PRELIMINARY STRUCTURAL REPORT

EXISTING BARN

MILL BANK

Ref: 20621

North Elevation [facing road] (1:100)

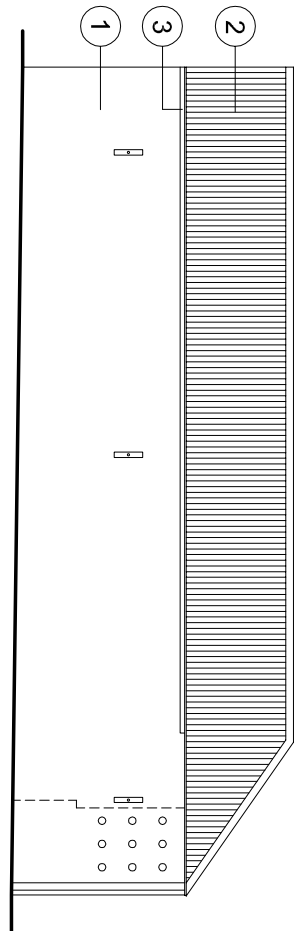
Along the front elevation varying types of brickwork was noted, particularly at the right hand corner – see photograph 1.

Slightly sloping new bricks have been added – see photograph 2, with a large vertical crack present midway along the wall – see photograph 3.

The previously mentioned cracking to the front wall was noted internally – see photograph 7.

It is envisaged that the front right hand wall will need to be rebuilt from the location of the vertical crack to the right hand corner.

South Elevation

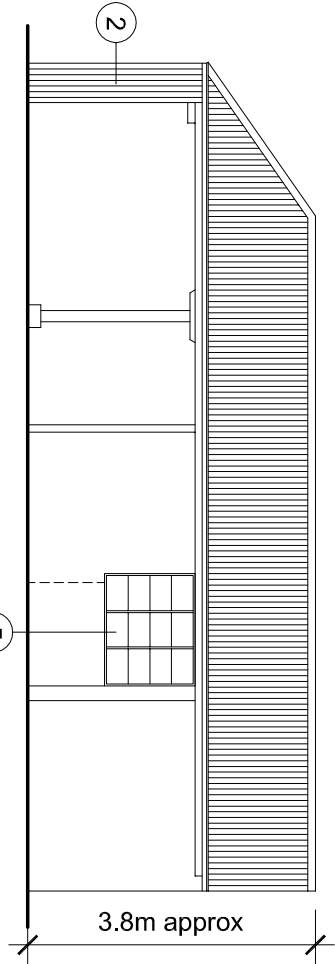
The rear elevation – see photograph 5, has infill brickwork between timber framing, with the left hand portion remaining open.

A vertical gap between the timber posts and the wall was also visible – see photograph 6.

Unfortunately the timber columns to the rear and gable elevations are decayed and not vertical.

The timber supports to the West gable and rear elevation should be removed, with support to the roof structure provided by new masonry walls and piers.

West Elevation

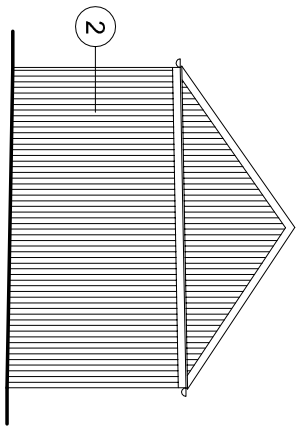
Further signs of new brickwork was noted to the left hand gable wall, with new bricks visible to both sides of the doorway – see photograph 4.
